From: [Chad Bala](#)
To: [Kelly Bacon \(CD\)](#); [Jeremy Johnston](#)
Cc: [Dan Carlson](#); [Pat Nicholson](#)
Subject: Sweetwater Response
Date: Monday, June 14, 2021 2:37:45 PM
Attachments: [SwtWtr Resp. 6-14-21.pdf](#)
[Swtwtr site plan fn16-11-21 Revised plan copy 2.pdf](#)

I hope you all had a great weekend? I am emailing to follow up on the Sweetwater conditional use permit. I have attached two items that meet the needs directly related to our zoom call/conference call regarding this conditional use permit application.

Revised Site Plan
 Submittal Date
 6-11-21

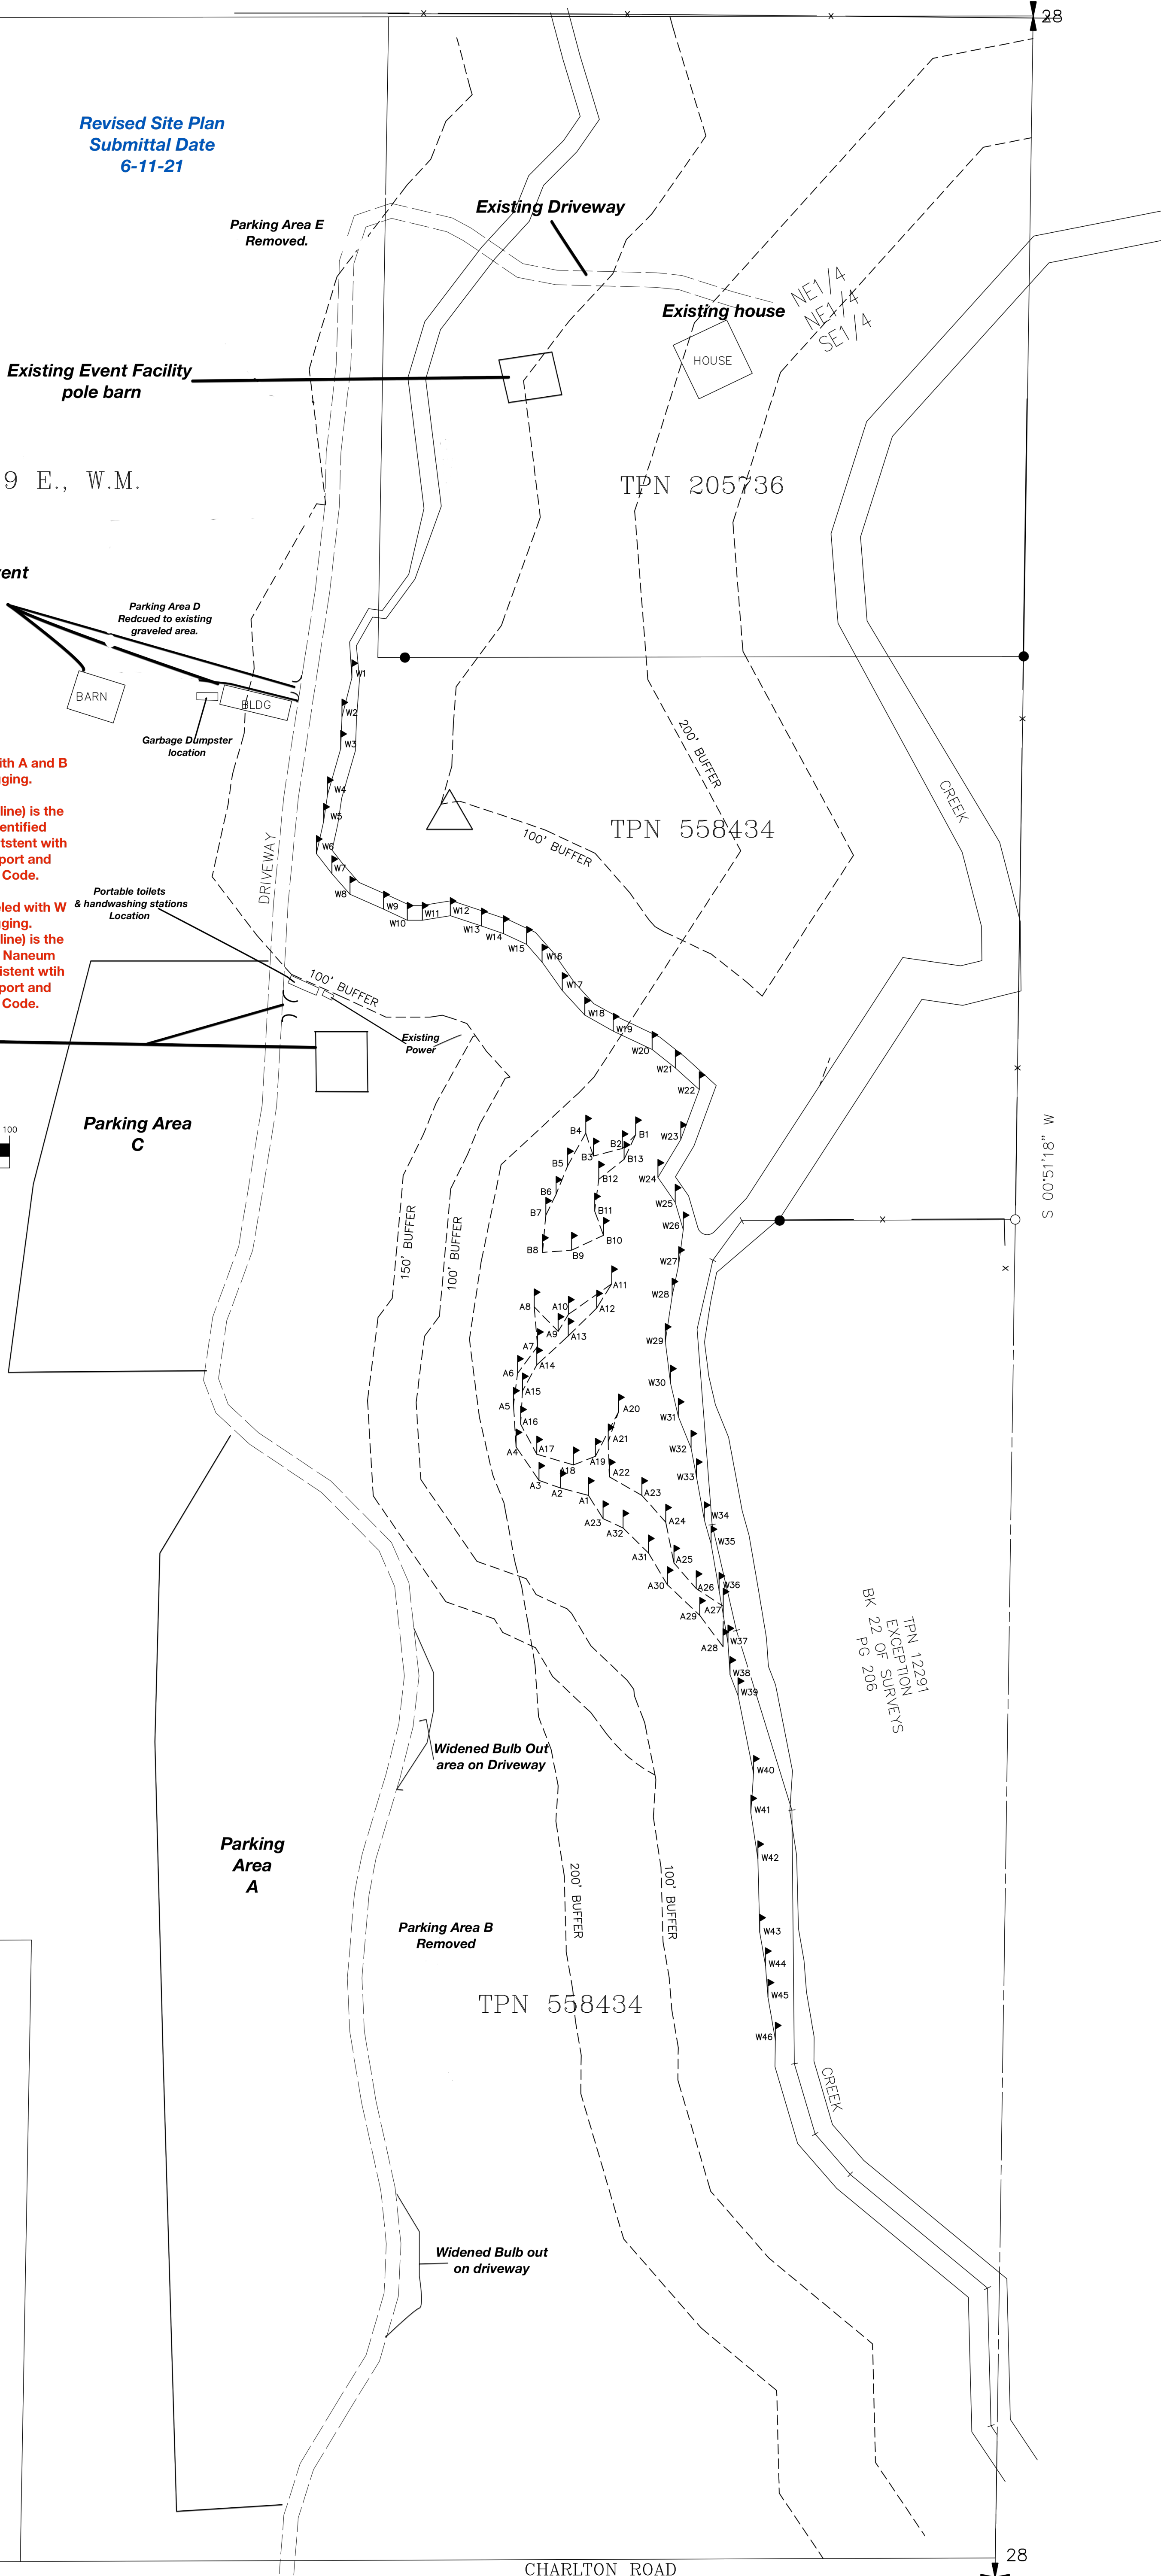
1. Parking Area E has been removed.
2. Parking Area D has been reduced down to the existing gravel parking area associated with the structures and round-pen at that location.
3. Parking Area B has been removed.
4. Driveway (bulb outs) have been added along the driveway per Fire Marshal direction.
